From: Andrew Knowles [REDACTED]
Sent: 09 October 2019 16:29
To: Zac Denton <Zac.Denton@arun.gov.uk>
Subject: Re: R/194/19/HH - Confirmation of materials

Drig No.: SBS/532/05A

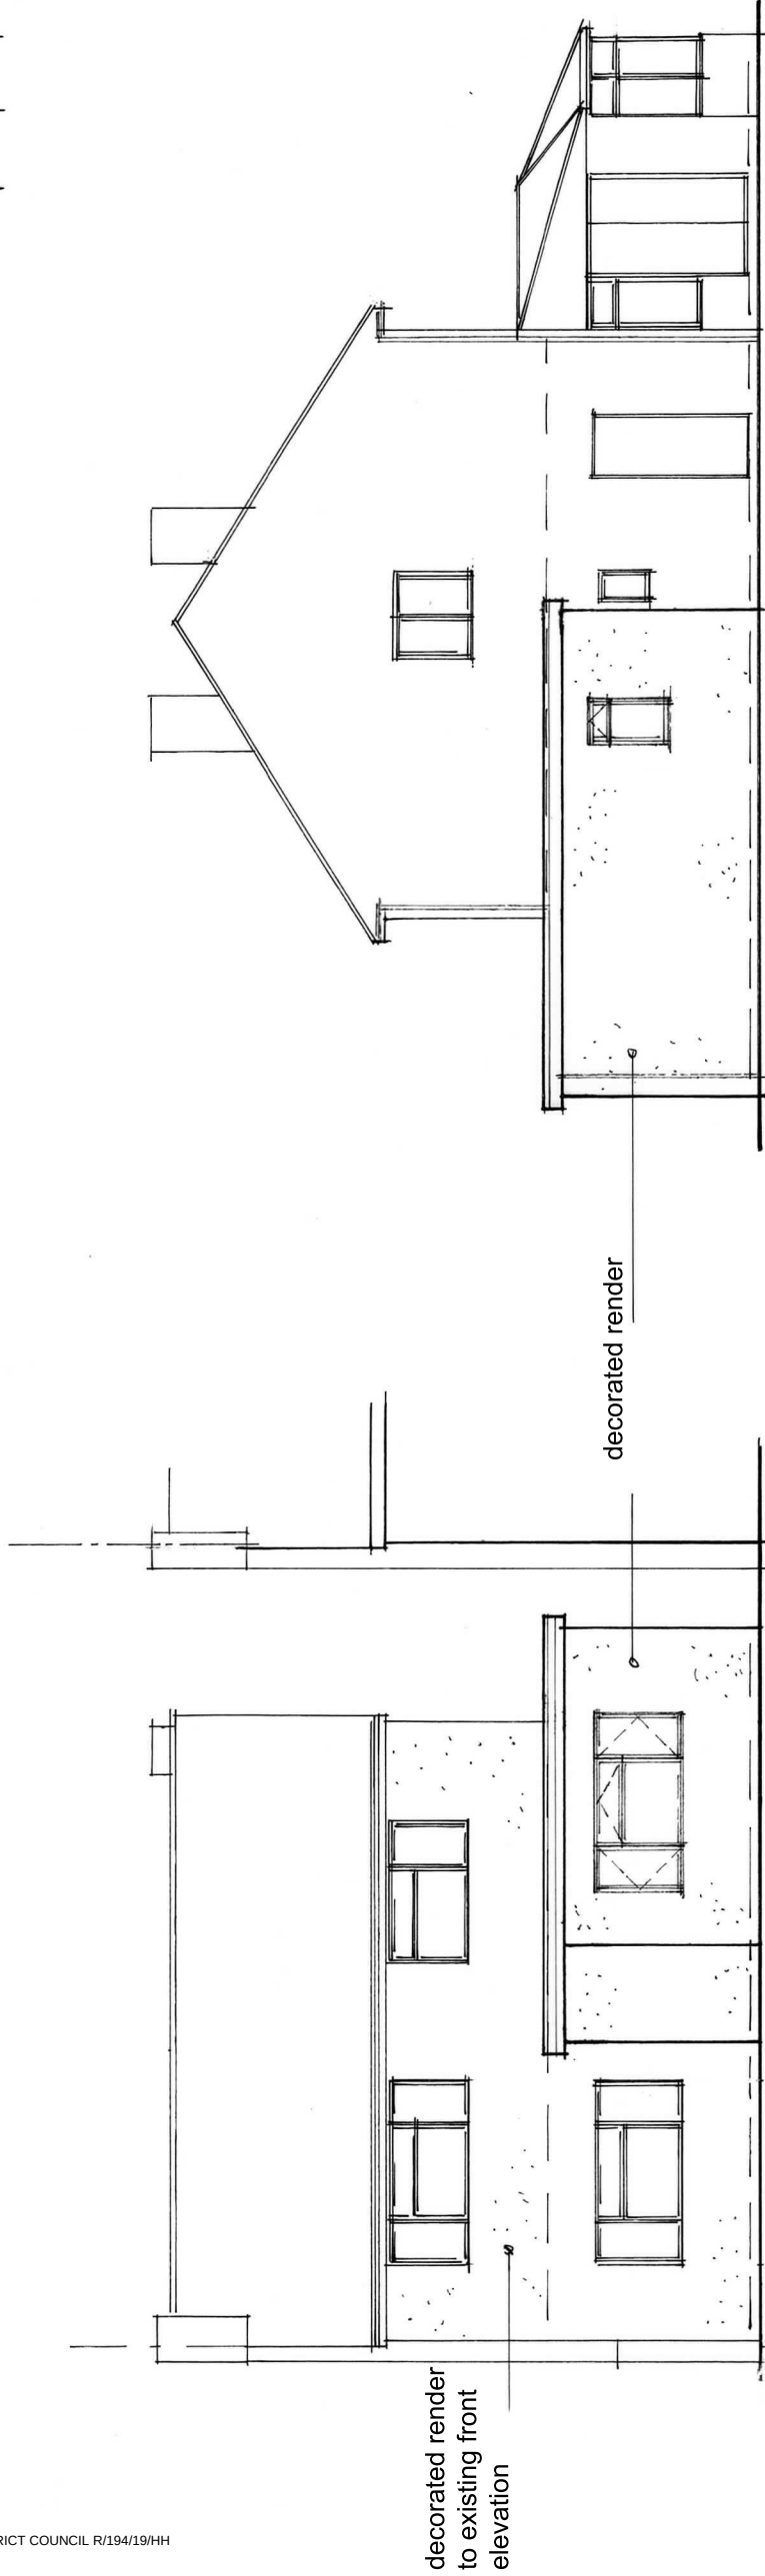
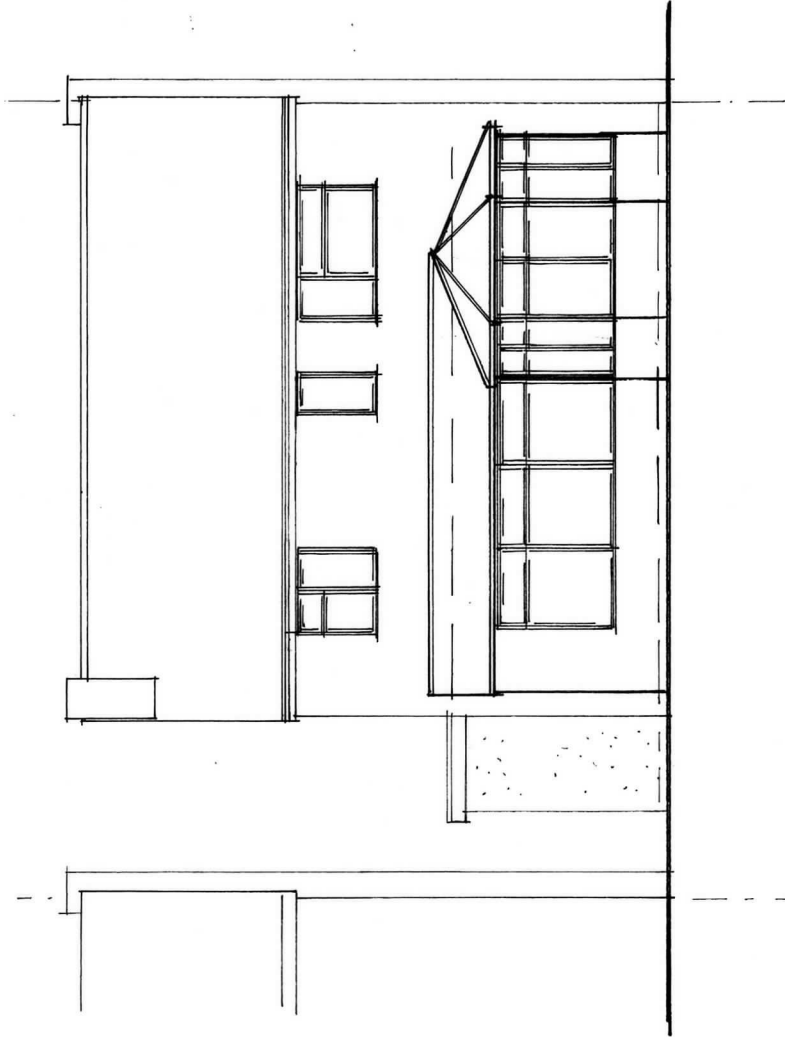
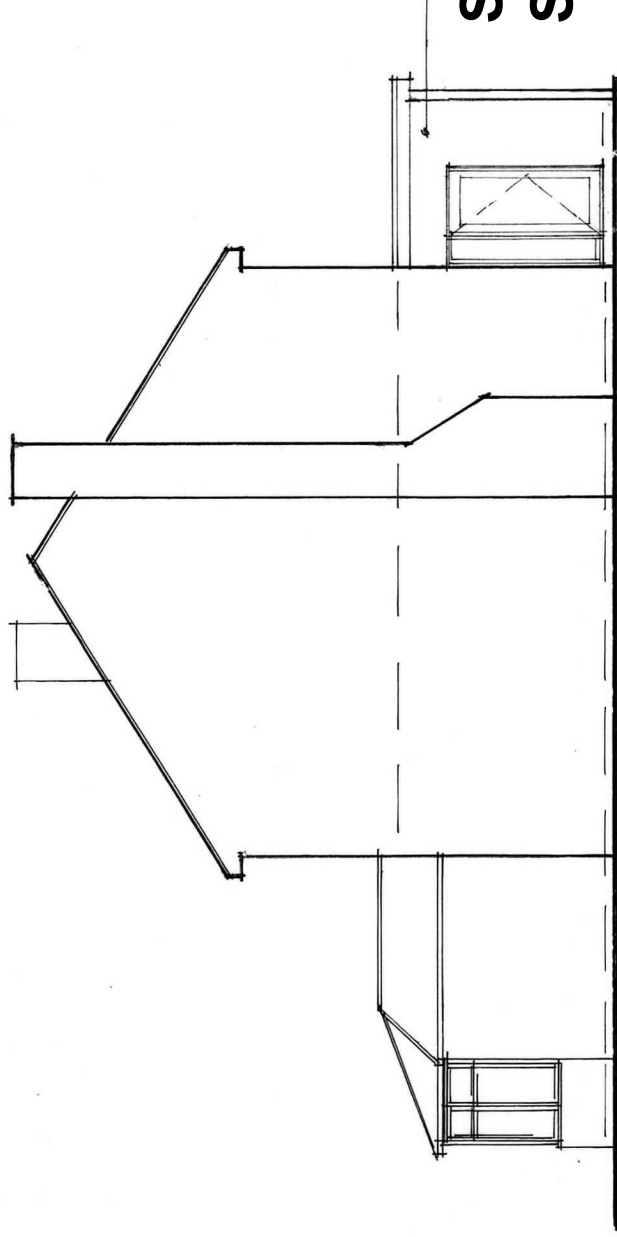
With regard to the render, the query was regarding the colour, or any details you have of said render.

Are you able to confirm the details of the proposed materials for the above application?

I have spoken to the applicant and the render will be a flat finish sand and cement or proprietary render. The colour will be neutral probably white, beige or a light grey.

The walls finishes are decorated render (as stated on drawing 05A) and the flat roof will be weathered with GRP or bituminous felt.
